PLANNING CONSULTATION RESPONSE

Application No	2026/0603
Proposal	Permission in principle for residential development of up to 5 additional dwellings (6 dwellings in total, including retained Willow Cottage).
Address	Willow Cottage, Carlton Road, Carlton, Barnsley, S71 3HX
Date of Consultation Reply	17/08/2026
Consultee	Katie Lawrence, Planning Ecologist

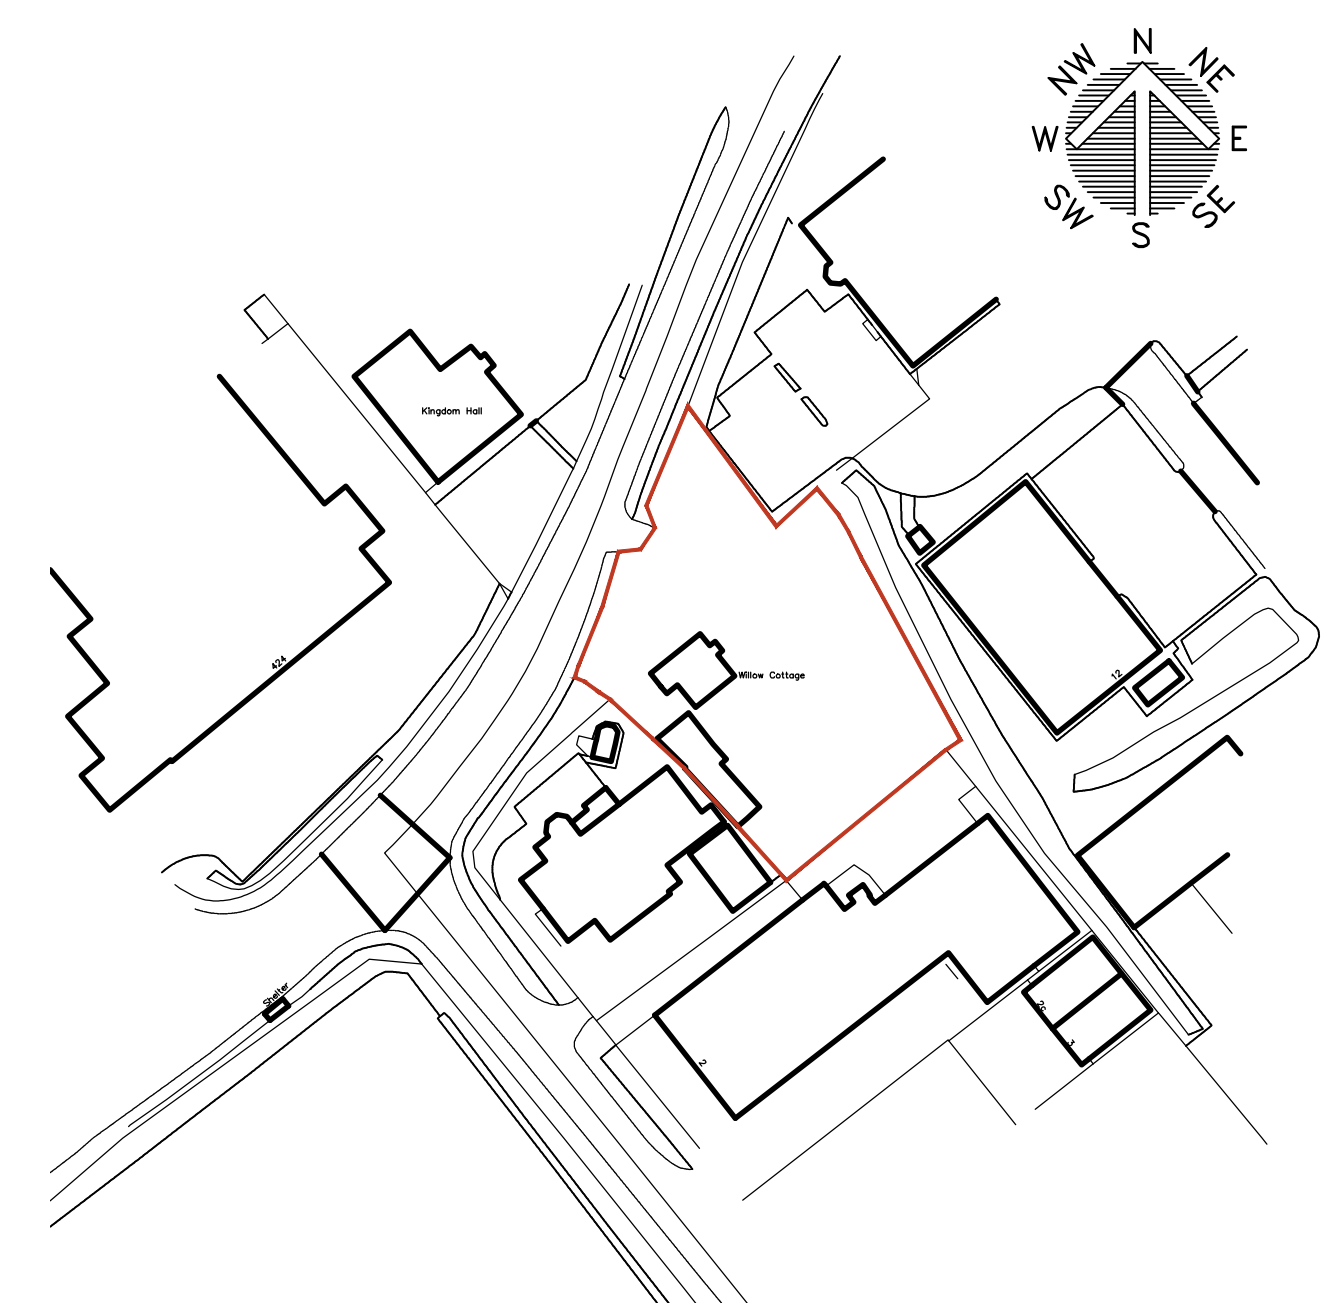
- Biodiversity & Geodiversity policy BIO1 and the SPDs Biodiversity & Geodiversity and Trees & Hedgerows should be complied with.
- When referring to the governments MAGIC website traditional orchard, a habitat of principal importance occurs within the proposals site. Planning policy BIO1 states that development will be expected to conserve and enhance the biodiversity and geological features of the borough by: Protecting and improving habitats, species, sites of ecological value and sites of geological value with particular regard to ... species and habitats of principal importance identified via Section 41 of the Natural Environment & Rural Communities Act 2006... Ecology reports which support the application should include an assessment of habitat within the site against the JNCC definition of traditional orchards <https://data.jncc.gov.uk/data/2829ce47-1ca5-41e7-bc1a-871c1cc0b3ae/UKBAP-BAPHabitats-56-TraditionalOrchards.pdf> If habitat within the site meets the description of traditional orchard, the applicant would likely have to consider altering the proposals to ensure the retention and improvement of the habitat.

- The proposals site comprises built structures and trees with a number of these features proposed for removal to facilitate the proposals. Any buildings or trees to be affected by works should be subject to a bat assessment by an appropriately qualified ecologist to the Bat Conservation Trust survey guidance (2023). If buildings/trees are assessed as having potential for bats, further specialist survey may be required to further consider the presence/absence of roosting bats and the potential impact of the proposals. If considered necessary, the results of the such further surveys would be required as part of the Stage 2 application.
